Please ask for: Mrs D Johnson
Email: daun.johnson@arun.gov.uk
Telephone: 01903 737762
Our Ref: AB/47/22/A
Your Ref:
Date: 25th April 2022

Town & Country Planning (Control of Advertisement) (England) Regulations 2007 (as amended)

Application for Consent to Display an Advertisement(s)

Development: 1 No externally illuminated hanging sign & 1 No externally illuminated informational sign.
Location: 2 Maltravers Street Arundel BN18 9AP

DATE: APRIL 2022
SCALE: 1:50 @ A3
JOB No. 1131
DRWG No. 120 Rev./

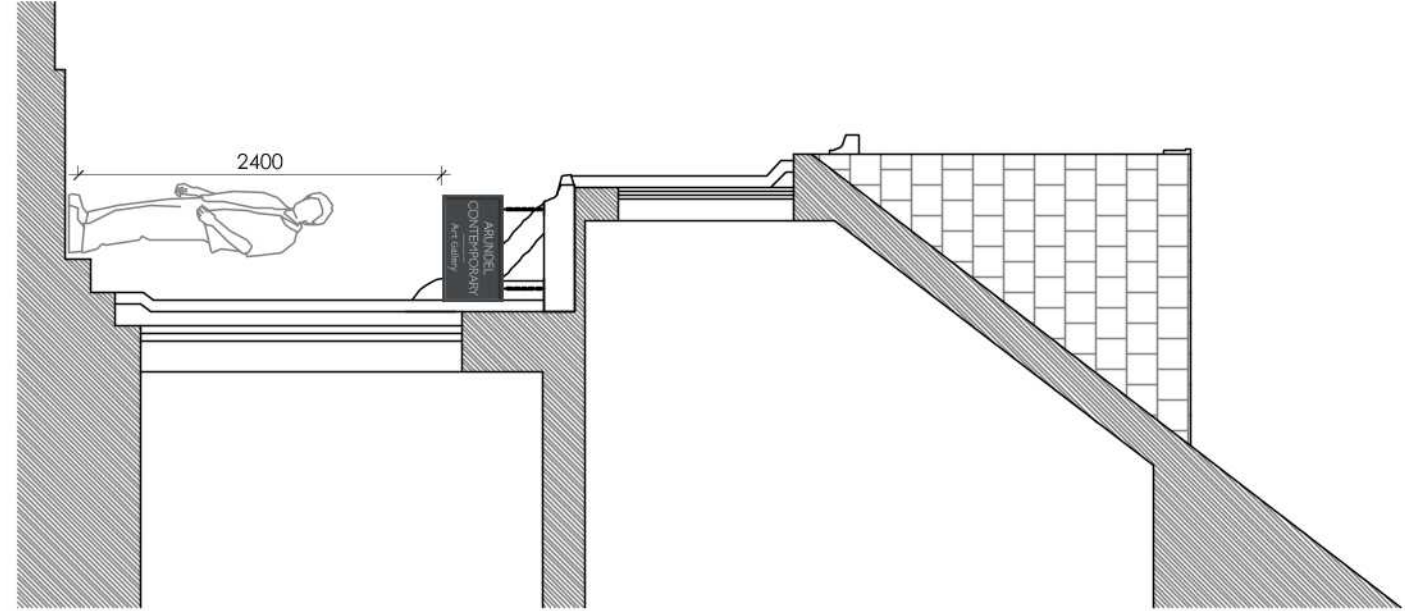
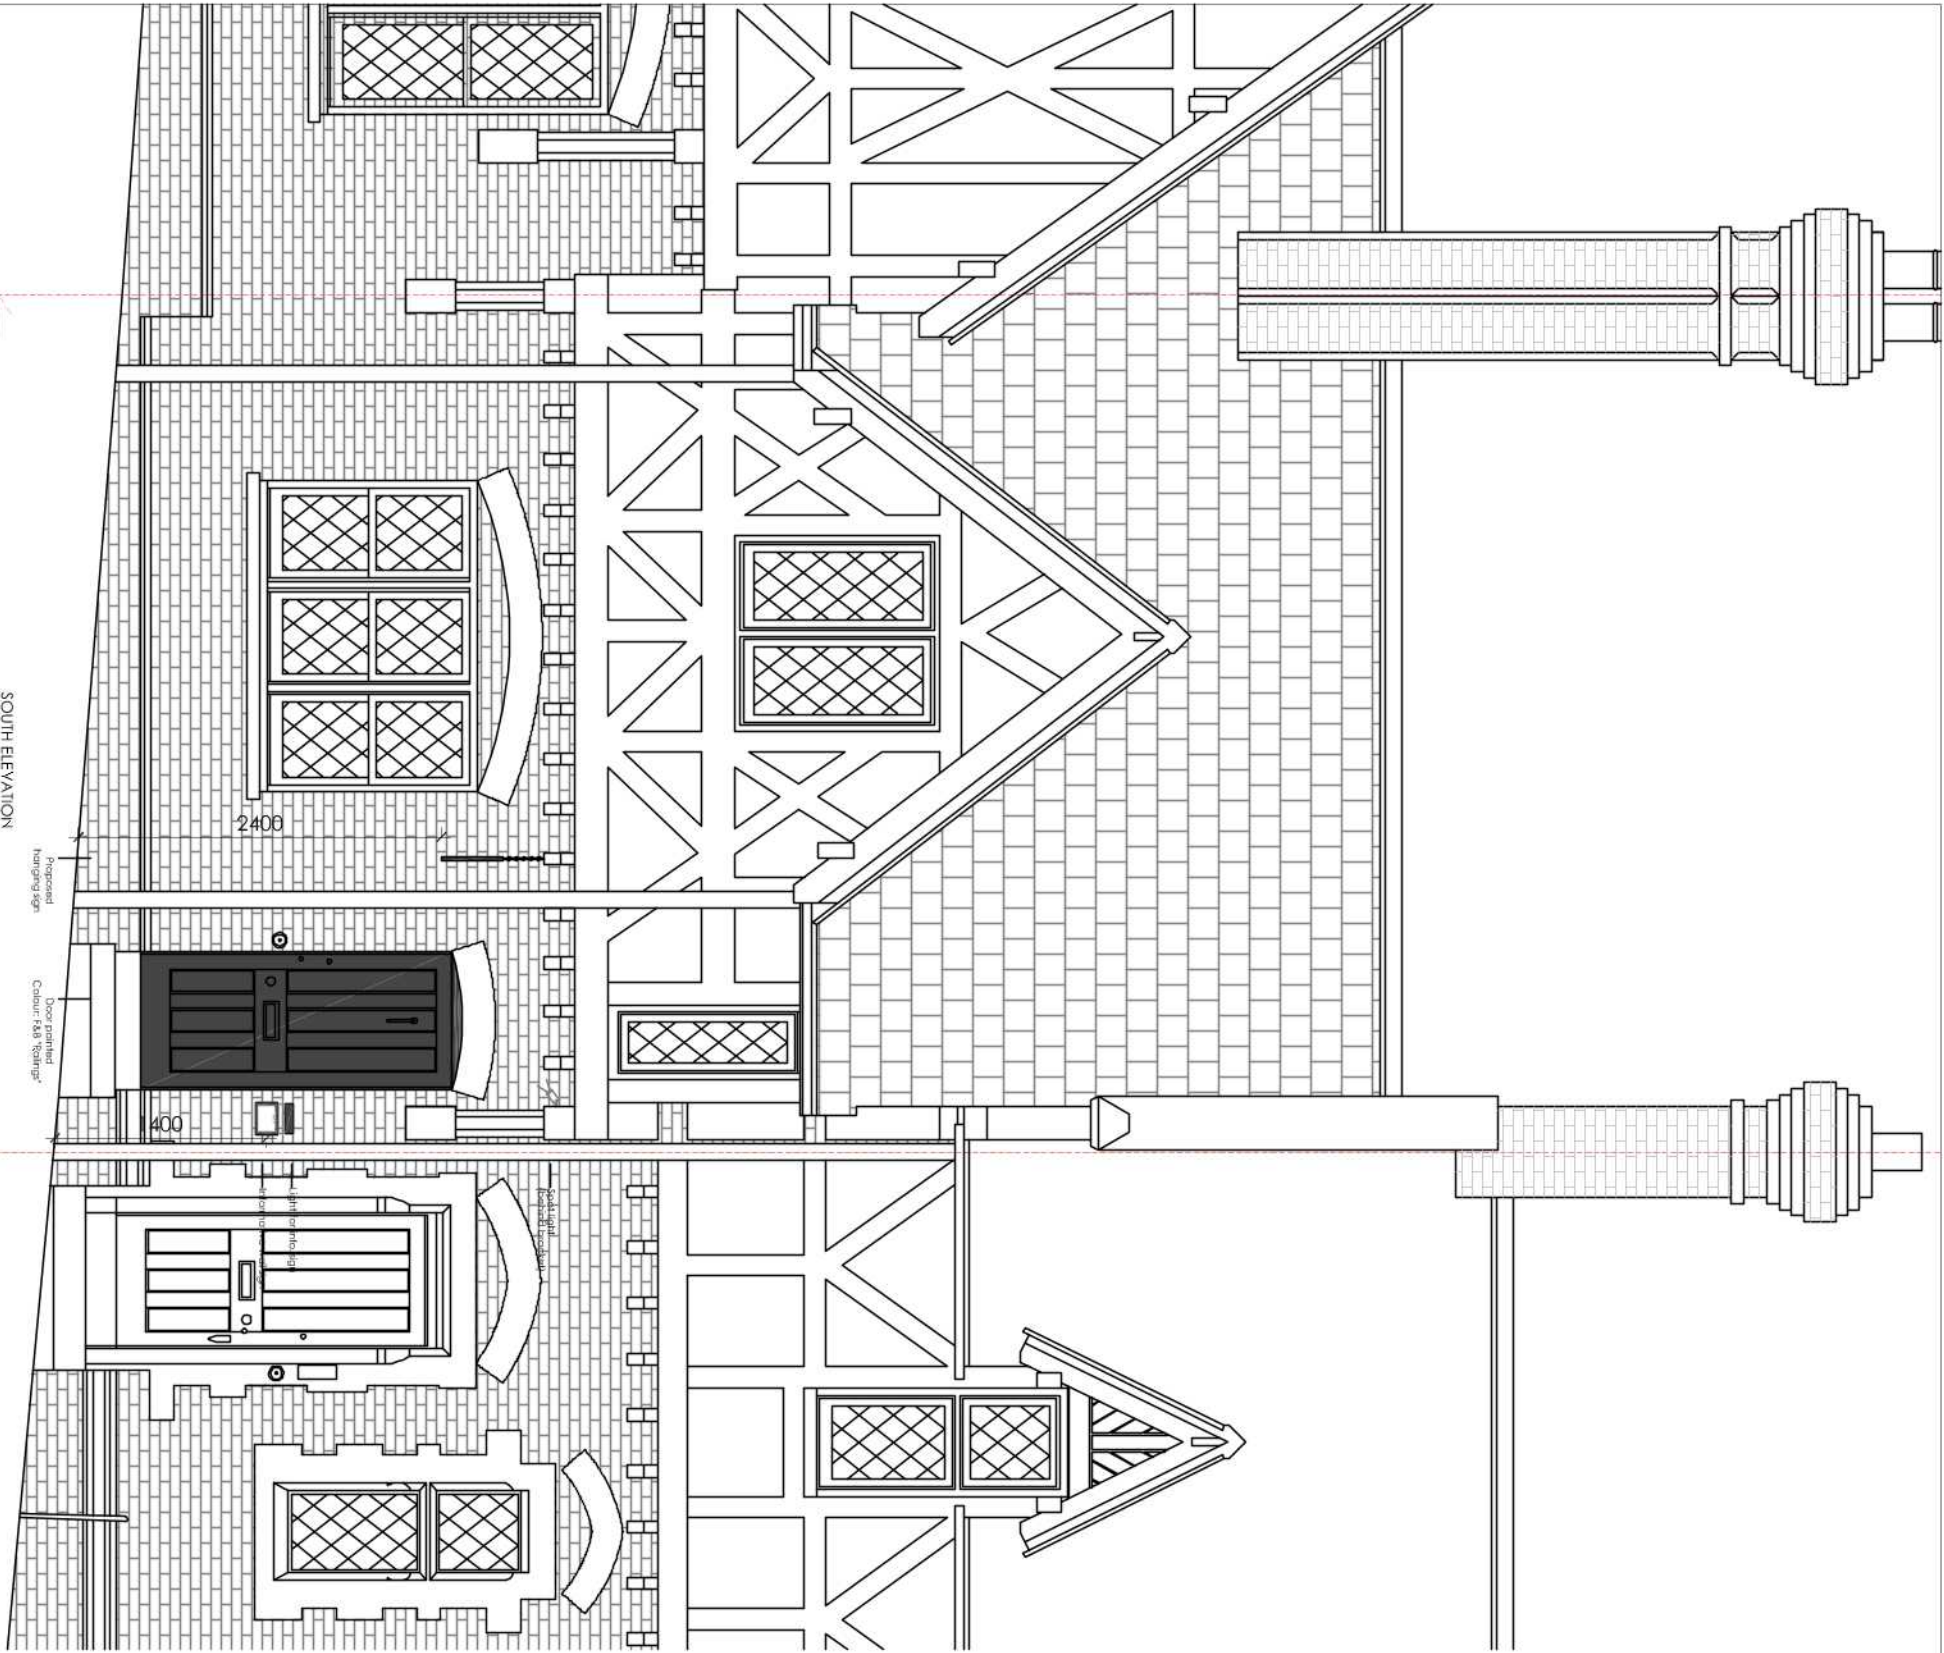
The legend on plan 120 says Proposed elevation while the lower left corner of the plan says existing elevation. Please clarify.
